Application No: A/253/21/OUT
Site Address: Land between 32 Downs Way and 2 Ambersham Crescent Angmering BN16 1AB
Description of works: Outline planning application with all matters reserved for the erection of 1 No bungalow dwelling with off street parking and private amenity space.

Thank you for your internet representation made on 17th January 2022 which has been recorded as an objection with the comments as follows:

Indicative Plans and Elevations

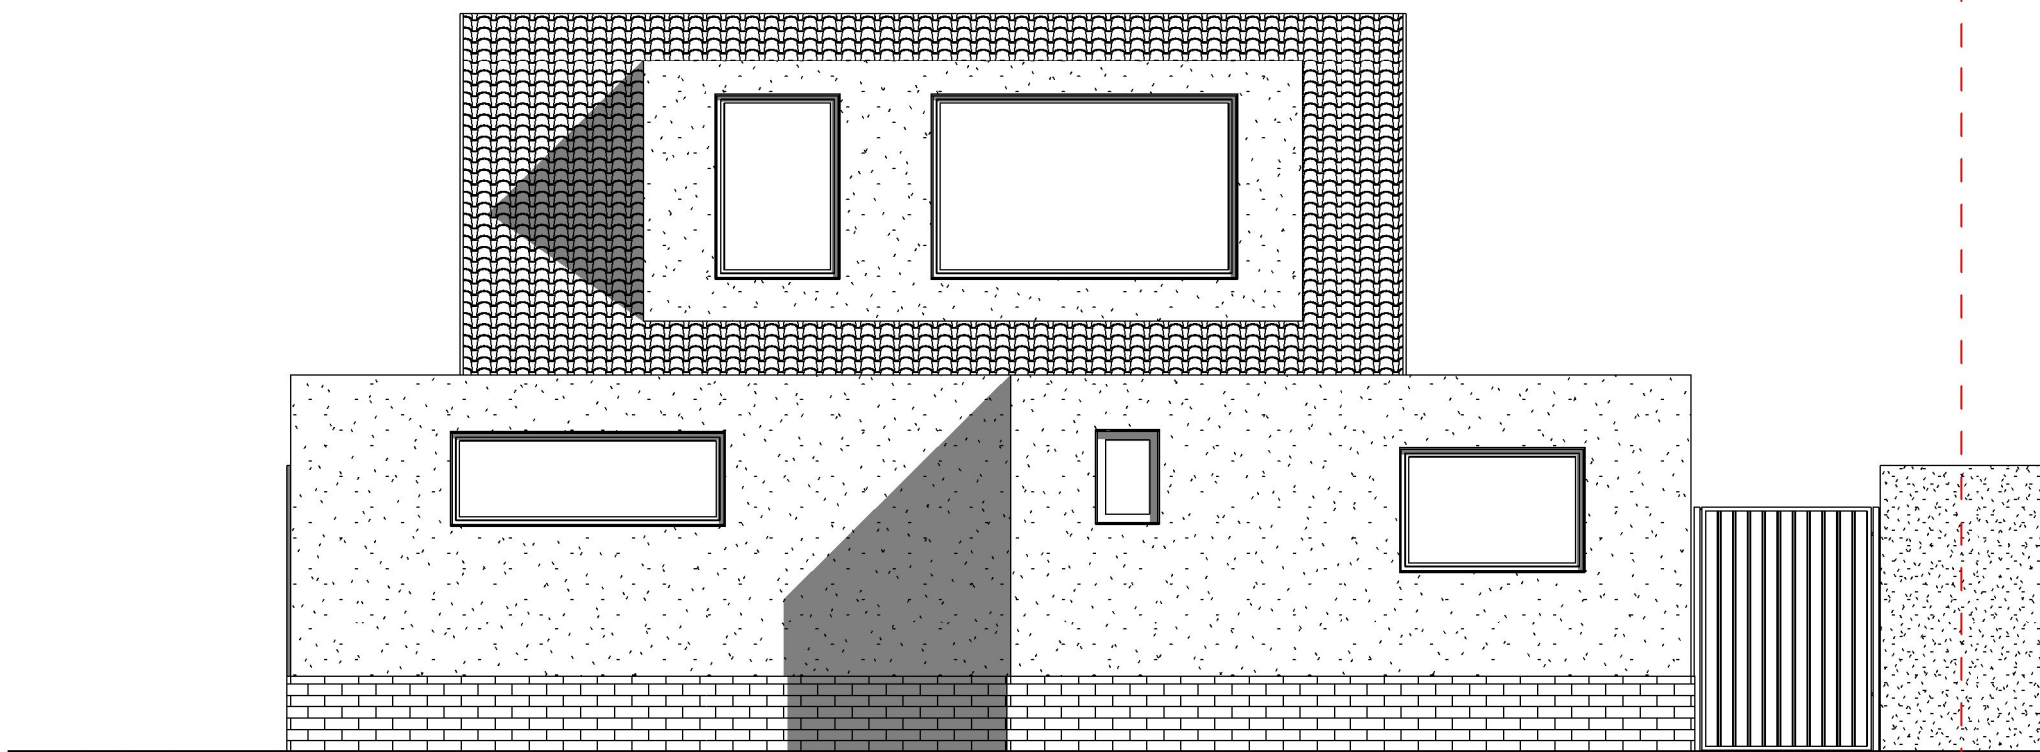
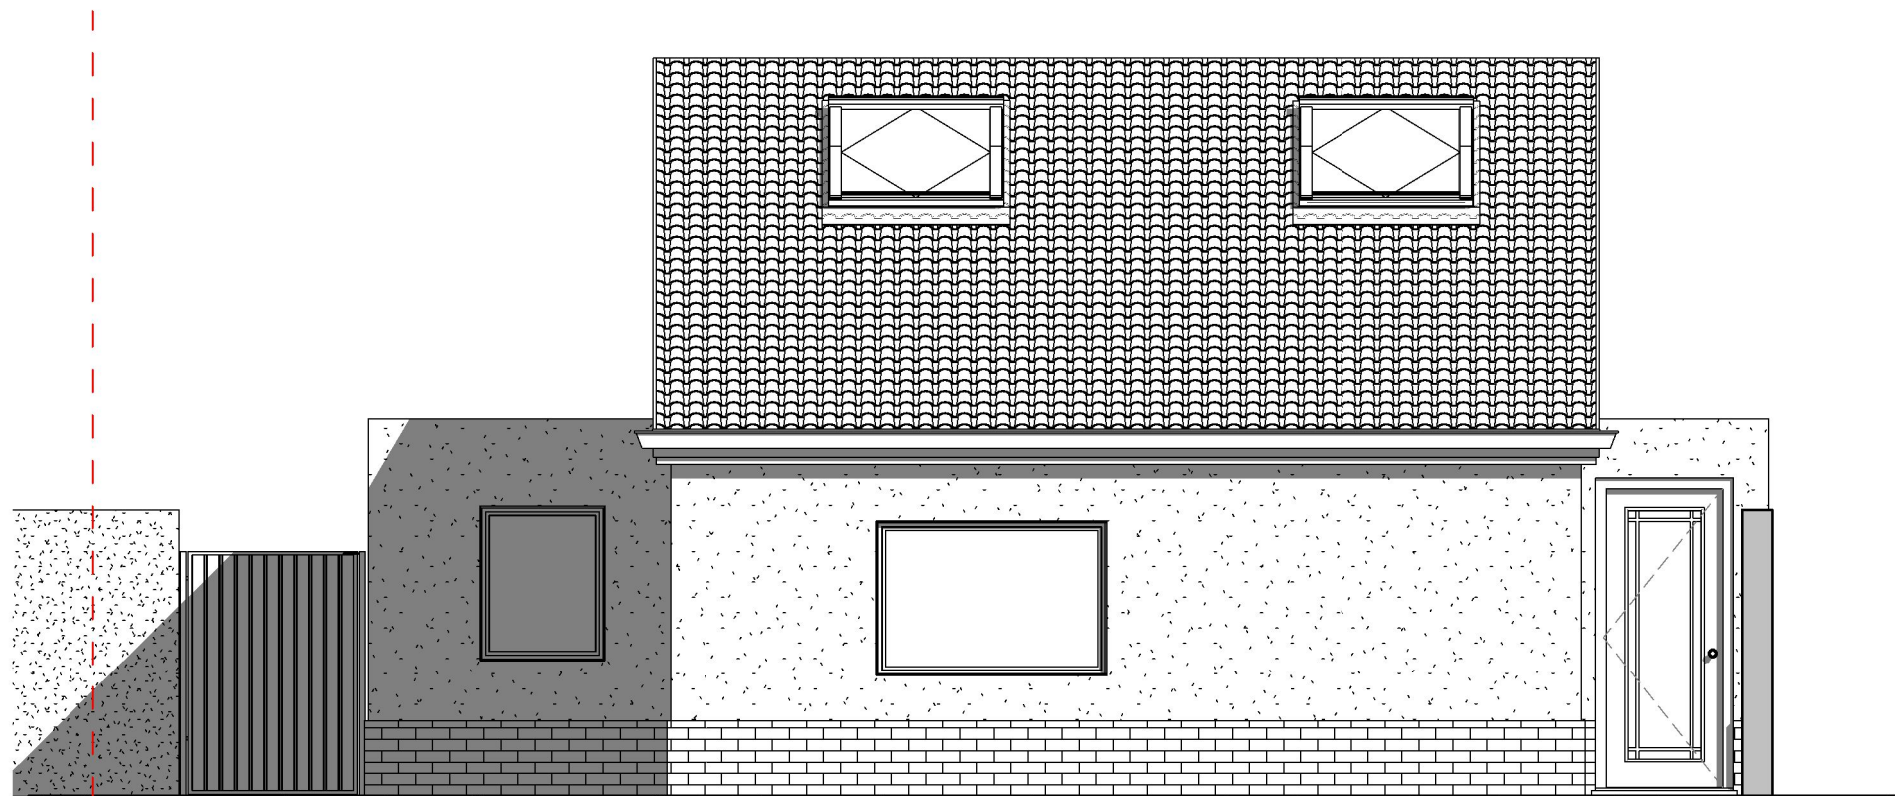
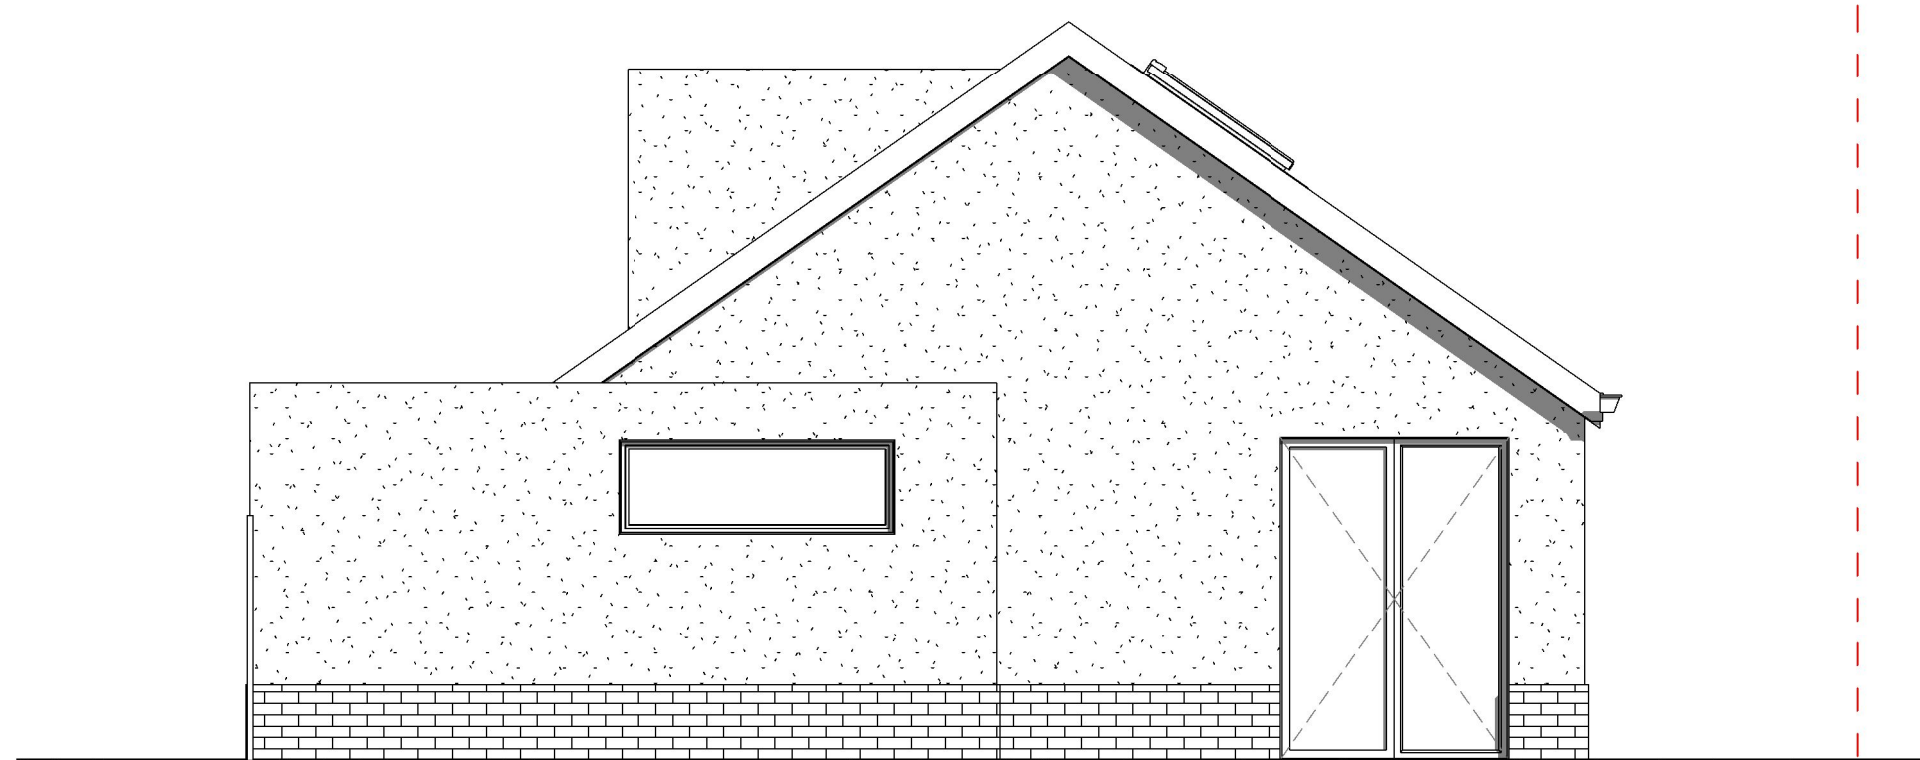
OBJECT the Design -flat roof is out of keeping with other Bungalows. OBJECT.
OBJECT Position outside of building and highway safety it's right on the junction which will become a nightmare of coming out of driveways with packed cars in the road it's a night mare now . Object to loss of privacy which will affect the immediate I OBJECT
